Thank you for the opportunity to comment on the Dunbar/Gill Short Plat, SP-08-00045. Pursuant to the Memorandum of Agreement between Kittitas County and the Washington State Department of Ecology all the future residential well connections serving the proposed lots shall be required to have meters installed. Metering results shall be recorded in a manner consistent with Kittitas County and Washington State Department of Ecology requirements.

SUBJECT: Dunbar/Gill Short Plat SP-08-45

Thank you for the opportunity to comment on the short plat of approximately 12.01 acres into 2 lots, proposed by Roger Gill [SP 08-00045]. We have reviewed the application and have the following comment.

**DUNBAR/GILL SHORT PLAT
 PART OF SECTION 25, T. 17 N., R. 19 E., W.M.
 KITTITAS COUNTY, WASHINGTON**

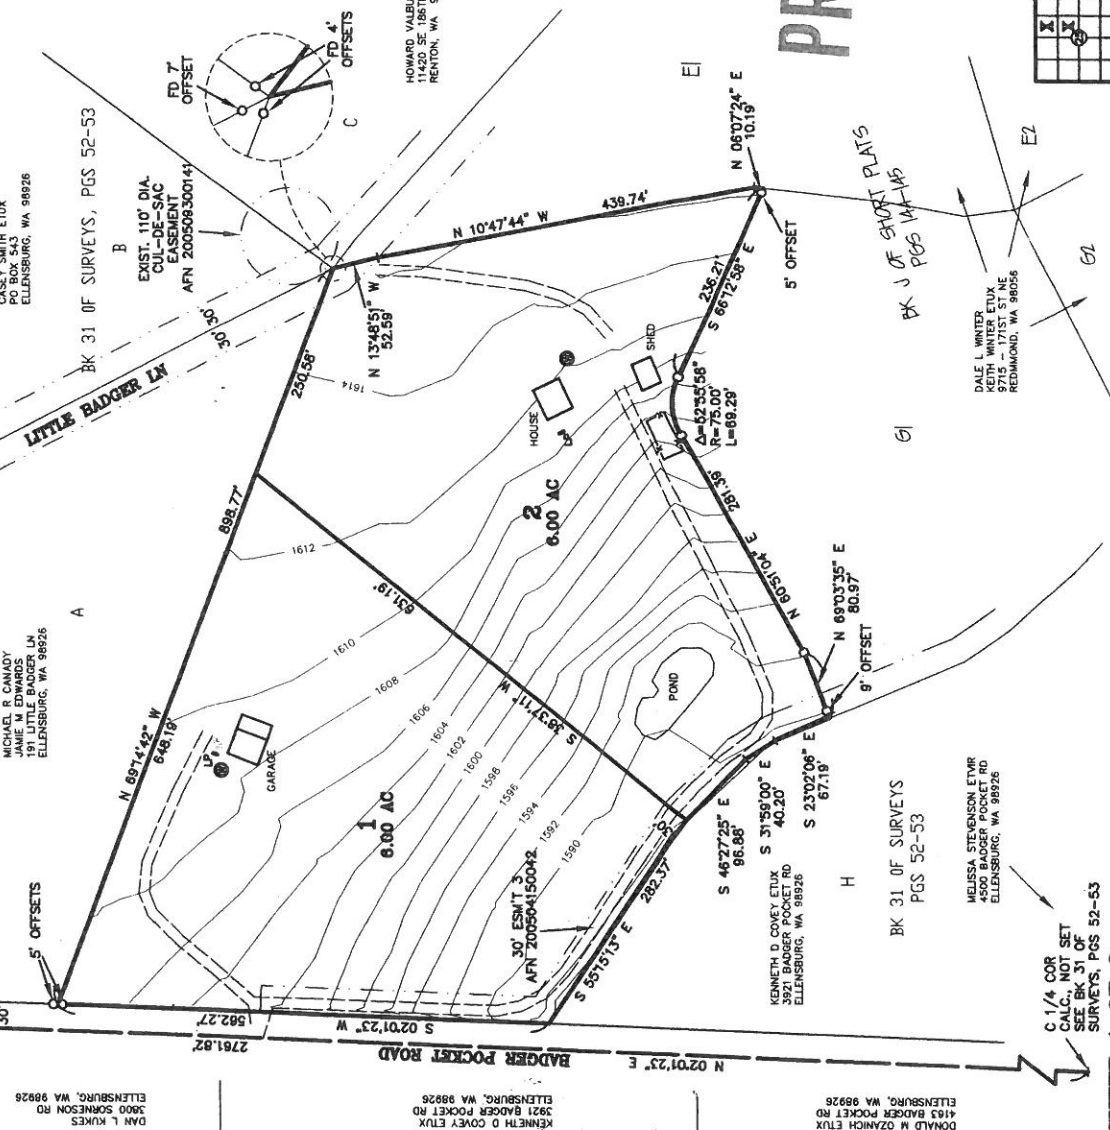
The potable water plat note is incorrect (plat note #8). Please replace the plat note with the following:

2. Private Road Improvements: Access from Badger Pocket Road to the point at which the driveway for Lot 2 turns off from the road serving Lots G1 and G2 shall be constructed as a Low-Density Private Road. A cul-de-sac shall be constructed at the end of the private road improvements. See Kittitas County Road Standards, 9/6/05 edition.

- a. Access easements shall be a minimum of 60' wide. The roadway shall have a minimum width of 20', with 1' shoulders, for a total width of 22'.
  - b. Minimum centerline radius will be 60'.

- c. The surface requirement is for a minimum gravel surface depth of 6".
  - d. Maximum grade is 12%.
  - e. Stopping site distance, reference AASHTO.

*"The approval of this division of land includes no guarantee that there is a legal right to withdraw groundwater within the land division. The approval of this division of land provides no guarantee that use of water under the ground water exemption (RCW 90.44.050) for this plat or any portion thereof will not be subject to curtailment by the Department of Ecology or a court of law. "*

*"Metering will be required on all residential well connections and metering results shall be recorded in a manner consistent with Kittitas County and Washington State Department of Ecology requirements."*
